Mountain Fox Garage Doors, AL-18-030

Please accept the following comments from El Paso County Public Health regarding the project referenced above:

# SITE PLAN

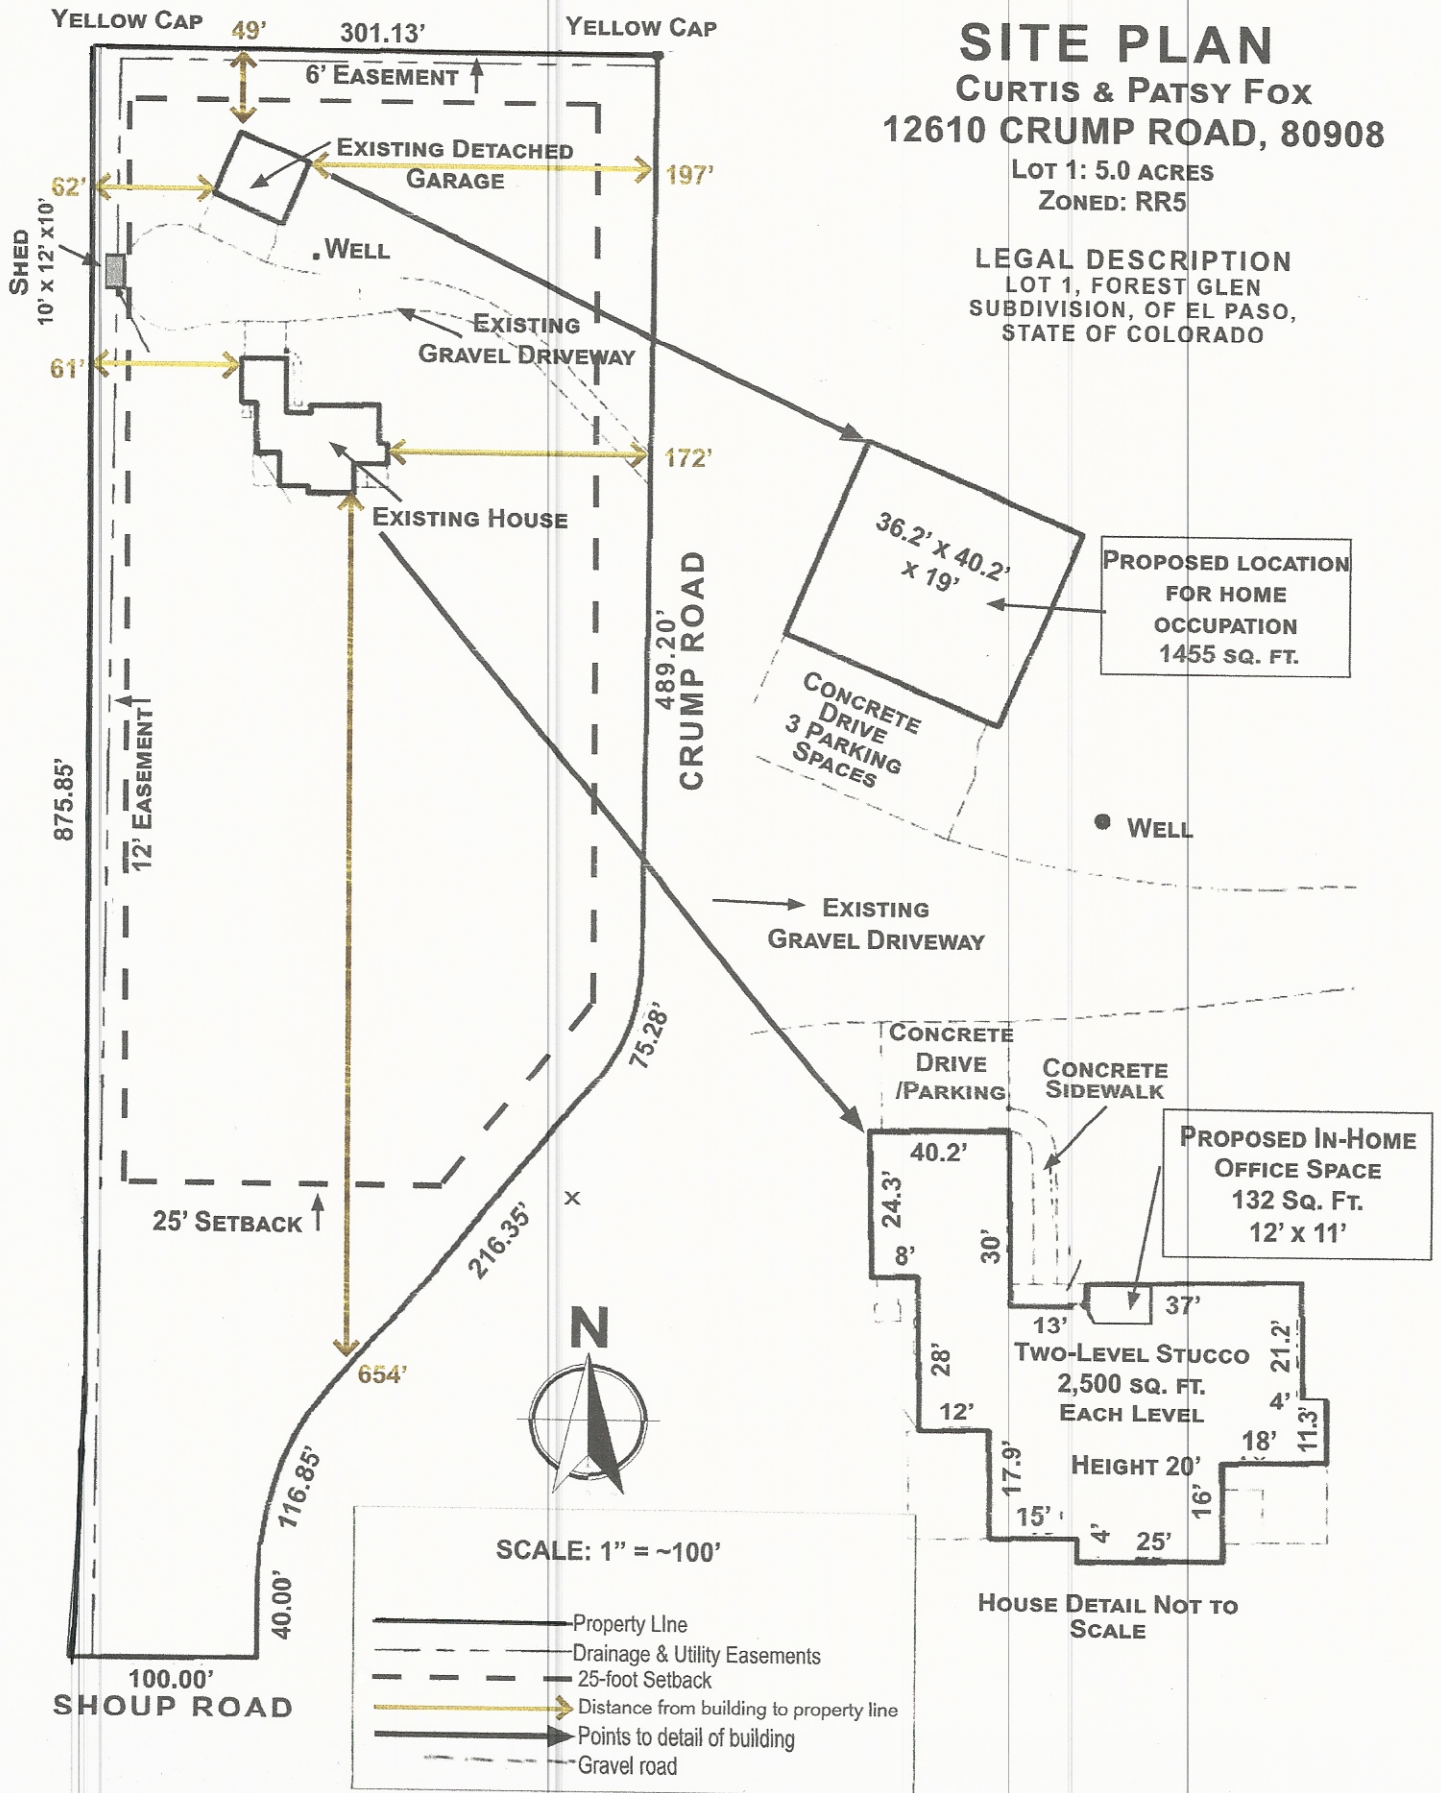
- A record of an approved, permitted on-site wastewater treatment system (OWTS) for this property indicates the OWTS was installed and approved for a 5-bedroom residence in 1996. The OWTS component locations are on file at El Paso County Public Health and are accessible through the El Paso County Assessor's Office website property search page. Please make sure that components of the OWTS are protected from vehicular traffic and other means of compaction.
- A Colorado Registered Professional Engineer must evaluate the existing OWTS, and provide a letter to El Paso County Health verifying the OWTS is sufficient for the additional 1.5 employees. NOTE: The existing septic tank capacity is adequate for an eight-bedroom house.
- Please reserve a secondary site on the property for the possibility of a future repair, addition, or replacement of the existing soil treatment area.
